Consultation Response from: Planning Policy Group		
Address: Ramsden House, Ramsden Street, Huddersfield, HD1 2TW		
Proposal: Change of use and alterations to offices (class B1) to form 45 studio apartments for students (class C3) and change of use of ground and first floor units to gym (class D2), flexible A1/A3/A5 use and ancillary student facilities along with associated external alterations and installation of roof top plant		
Date Responded: 09/01/2020	Responding Officer: Sarah Smith	Responding Ref:
Note: Comments on retailing and town centres policy only. The proposed development is in Huddersfield Town Centre in the Primary Shopping Area and on the primary shopping frontage, PSF 1 as designated in the Kirklees Local Plan adopted on 27th February 2019. Local Plan policies, LP14 shopping frontages, LP15 Residential uses in town centres, LP16 food and drink and the evening economy and LP17 Huddersfield Town Centre are relevant to the application. The shopping frontages policy LP14 states that 'Retail will remain the predominant use on each primary shopping frontage. Other main town centre uses will be acceptable where the frontage remains predominately in retail use taking acco

Proposed Ground Floor
Scale 1:100

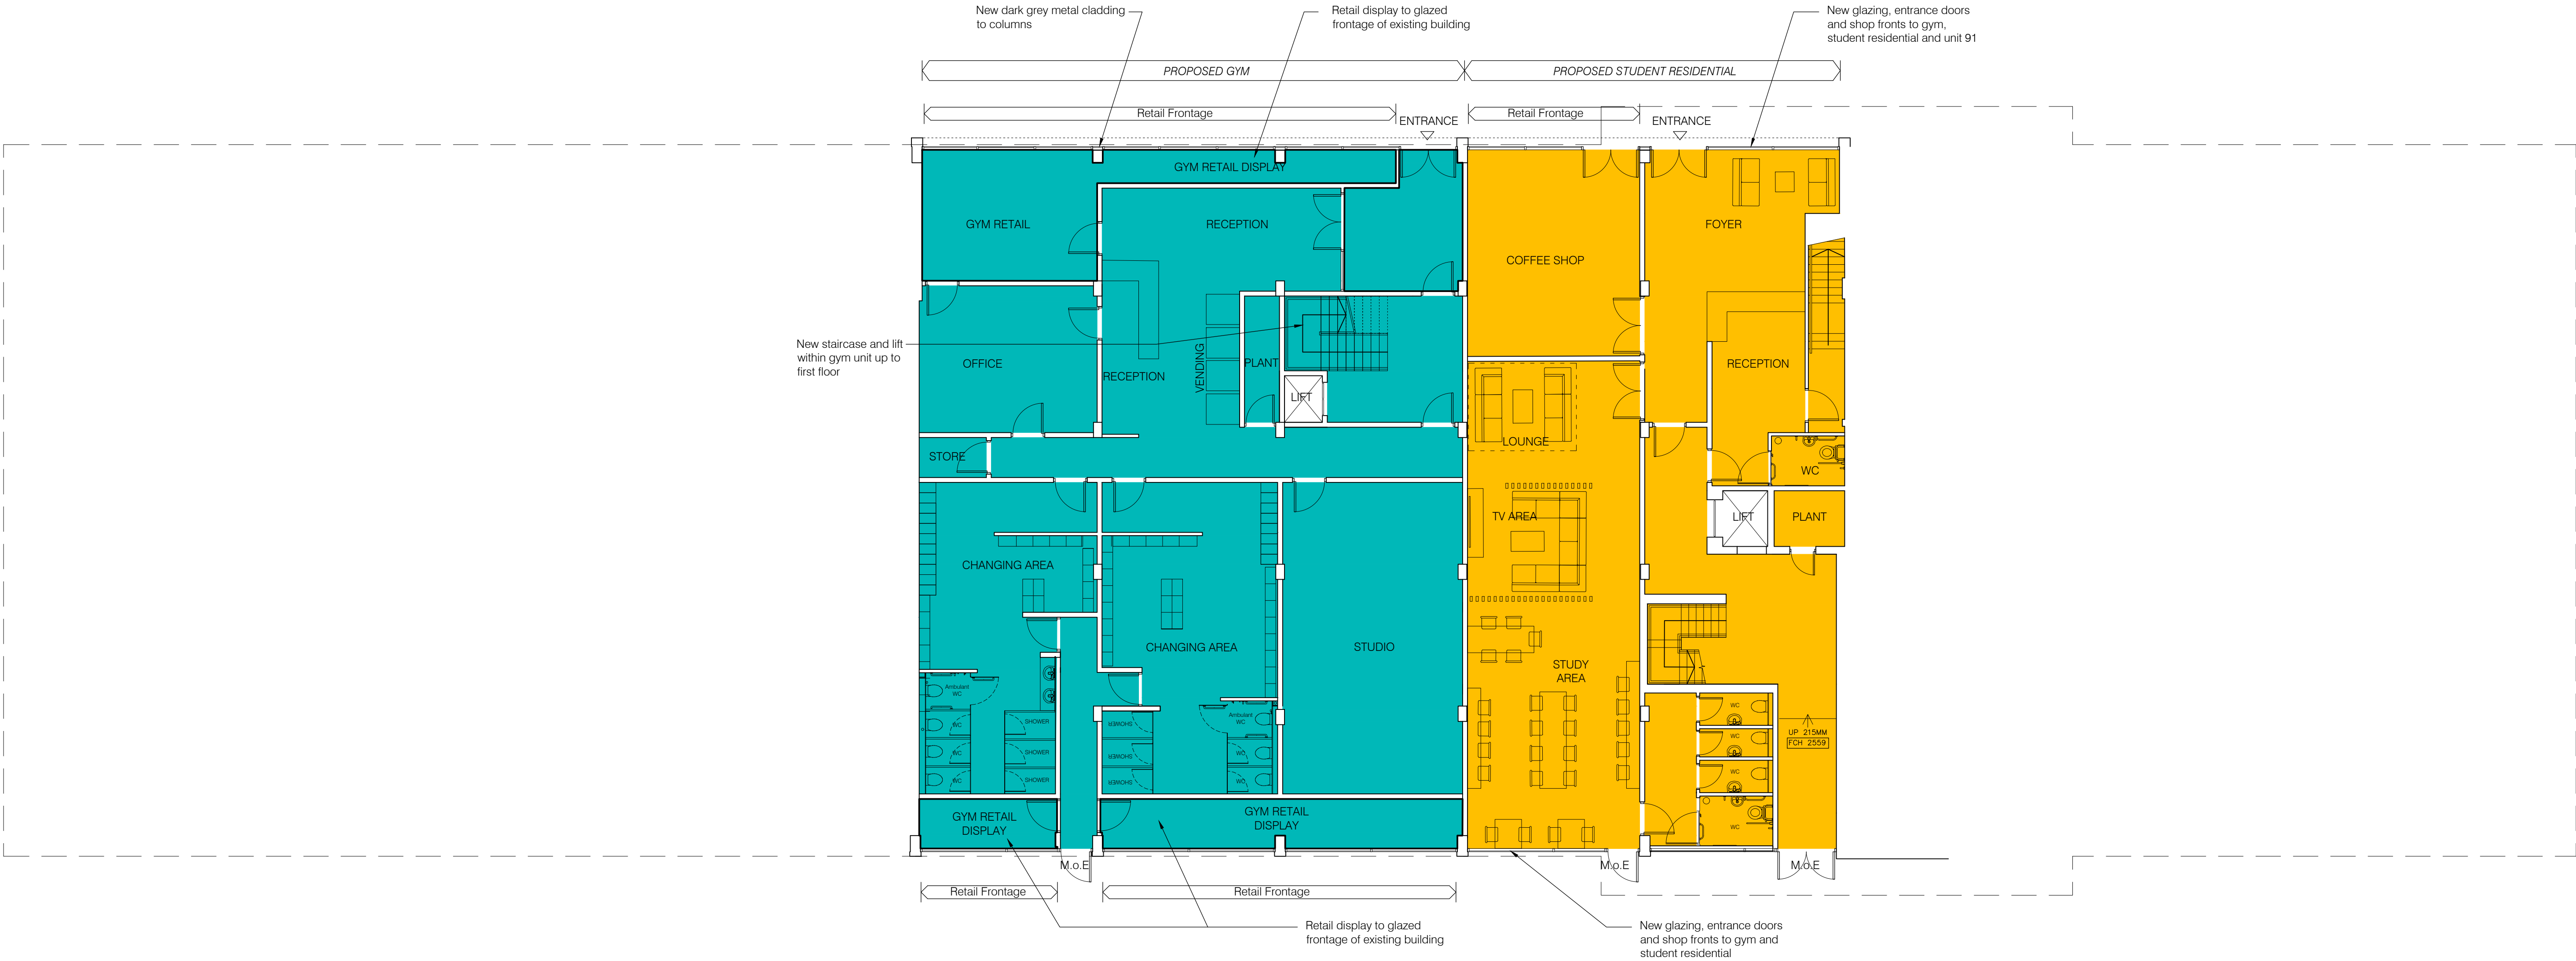
1. A1/A3 Gym reception/retail display/café area
2. A1/A3/A5 unit
3. Foyer

Taking account of the proposal the frontage would consist of 11 units and of those 55% would be in A1 retail use not taking account of the proposed use of the three units. The description of gym reception/retail display/café area does not equate to an A1/A3 use and could arguably be ancillary to the overall operation of the gym.

However, whilst with the new proposal it is slightly under the 60% threshold for A1 uses on a primary shopping frontage, one of the units proposes an A1/A3/A5 use. Permitted development allows the change of A1 to A3 (subject to prior approval) and A3 to A1 or A2. A5 use can change to A1, A2 or A3 all of which are main town centre uses and have the flexibility to be A1. New shop frontages are proposed for the new units which would retain an active street frontage.

Policy LP15 states that residential proposals shall not prejudice existing established uses and existing ground floor uses and active frontages should be protected and retained. Whilst the proposal retains an active frontage with the uses proposed, there are currently five units occupied by main town centre uses that would be lost. There are number of vacant units within Huddersfield's primary shopping area and the relocation of the existing uses needs to be supported.
